Re: SSD-4972, Four Points by Sheraton Expansion - 161 Sussex Street, Sydney

In response to the State Significant Development application for the expansion of the existing Four Points by Sheraton Hotel at 161 Sussex Street, DEXUS Property Group make the following submission.

Drawing Title	WEST COLOUR ELEVATION
Drawing Number	A-DA-0313
Scale	1:200 @ A0

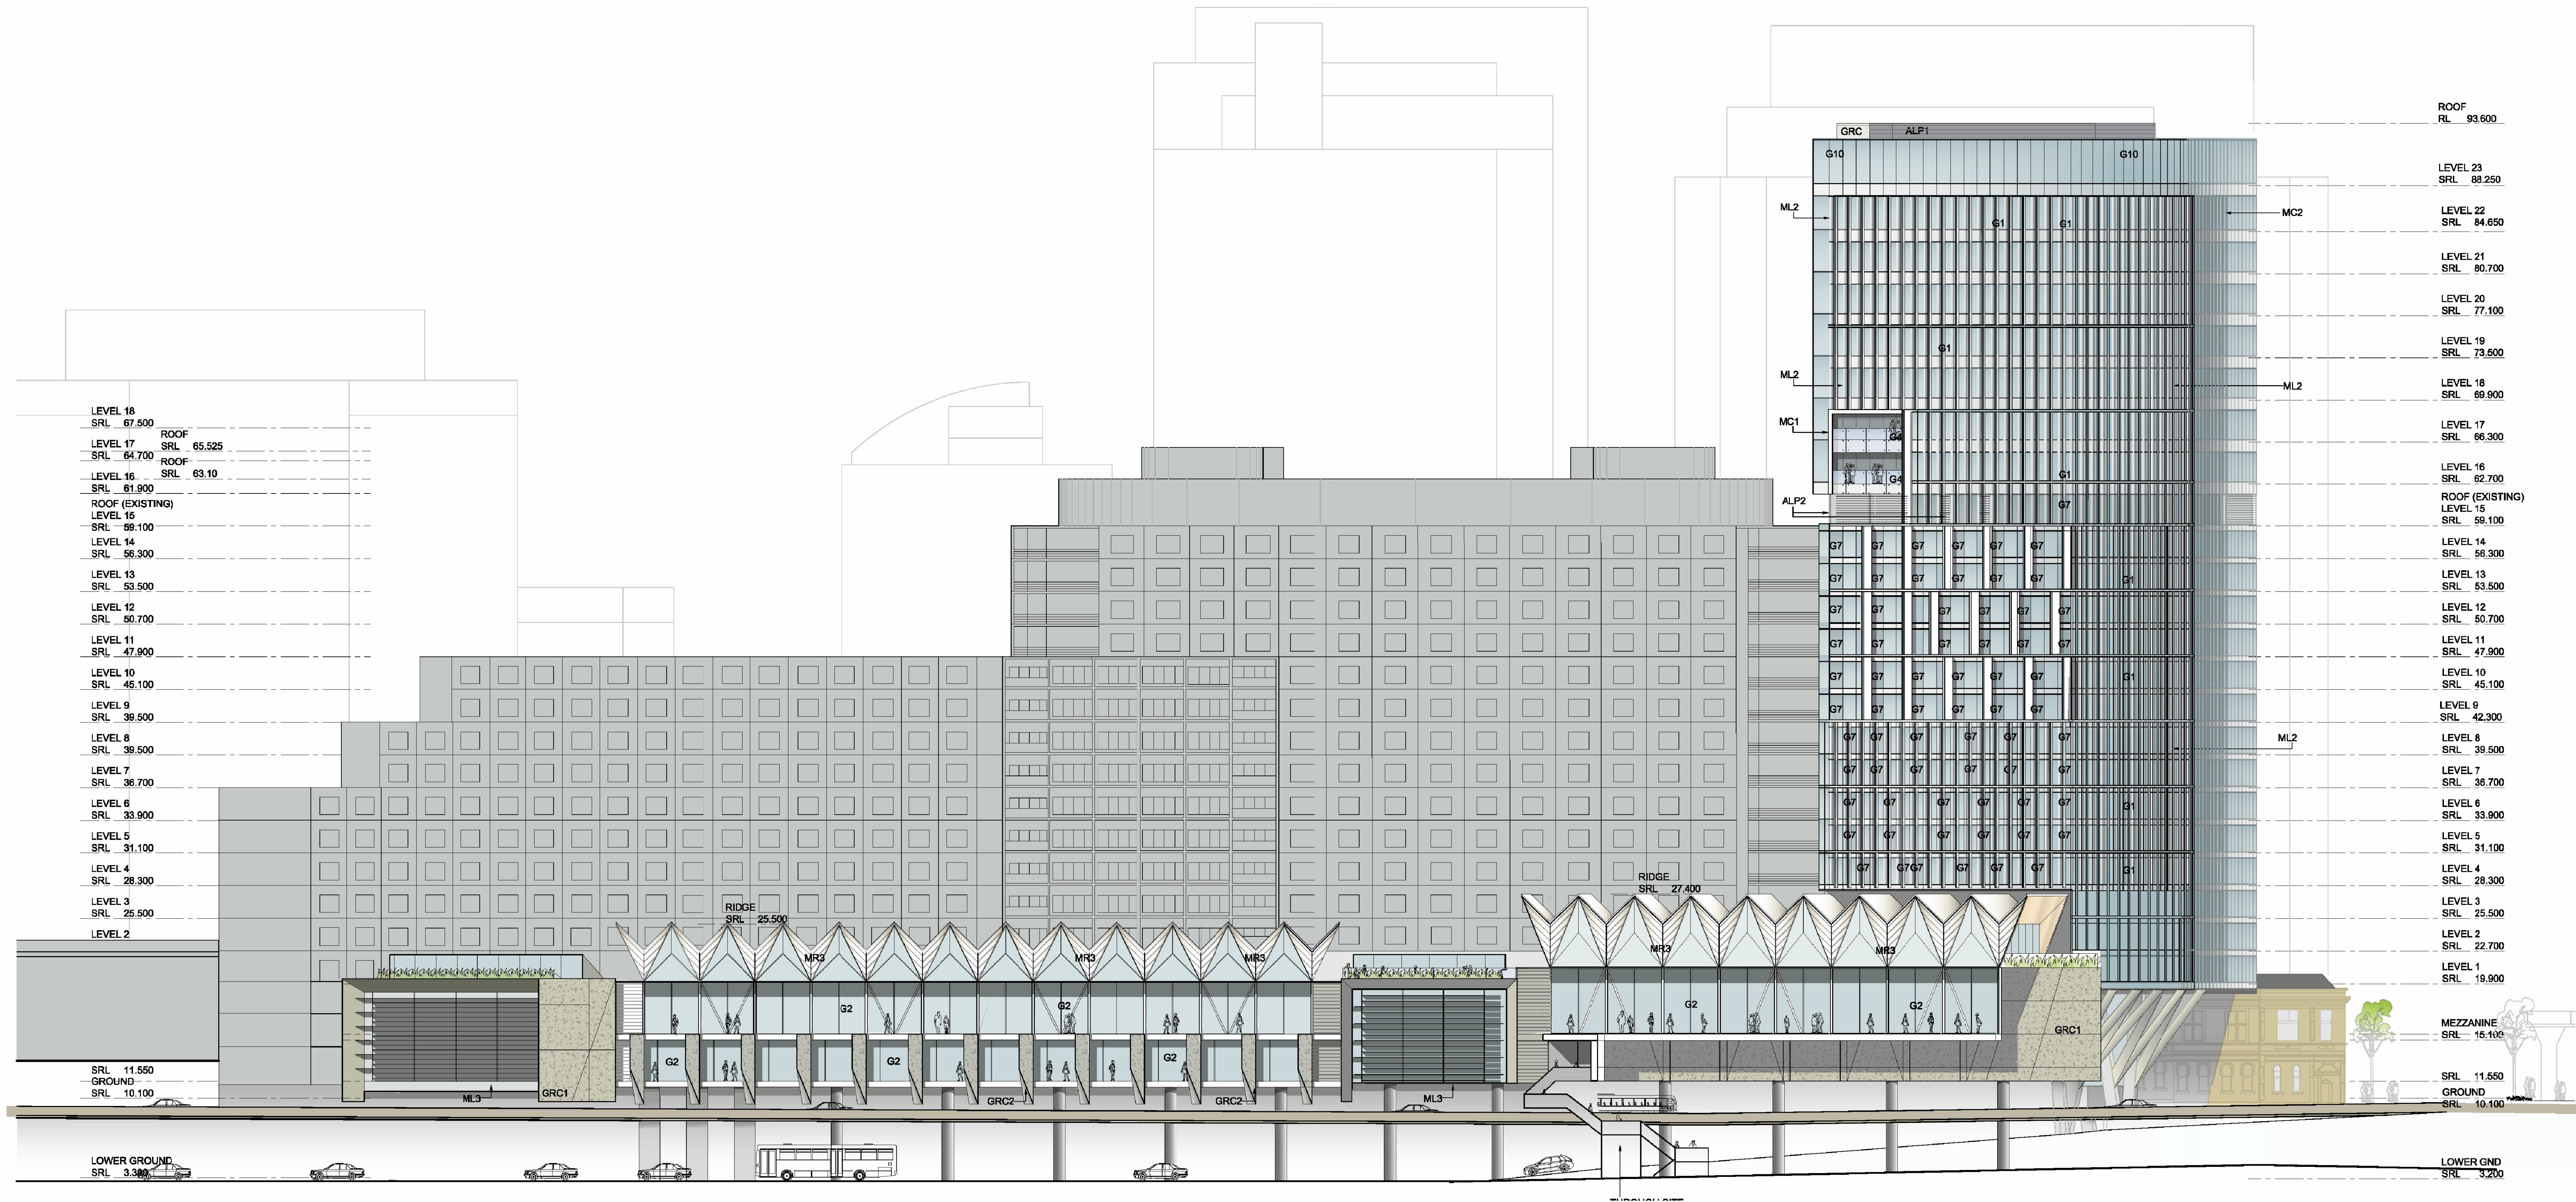
In our opinion the proposed tower is out of context with the scale of development on the western side of Sussex Street (between Market Street and King Street) and the water's edge of Darling Harbour.

The proposed tower does not respect the topography and built form of this precinct which primarily consists of smaller scale development, before stepping up in height and scale to the east up to the ridgeline of the CBD. The proposed tower, in combination with the existing hotel building envelope will create a very large "wall" effect which is inconsistent with the western fringe of the city.

Traditionally, heights of buildings at the scale of the proposed tower within the Sydney are generally located on the upper levels of the sloping western topography of the CBD and not as close to the water's edge as the proposed tower.

If approved this proposal may set a precedent for future development on the eastern side of Sussex Street of a similar scale and bulk, with a resultant extended wall along the western fringe of the CBD.

The level of impact of views of this proposal and the impacts the proposal will have on the built form of this part of the western CBD fringe should result in the reduction in the proposed height of the tower to mitigate against these impacts.
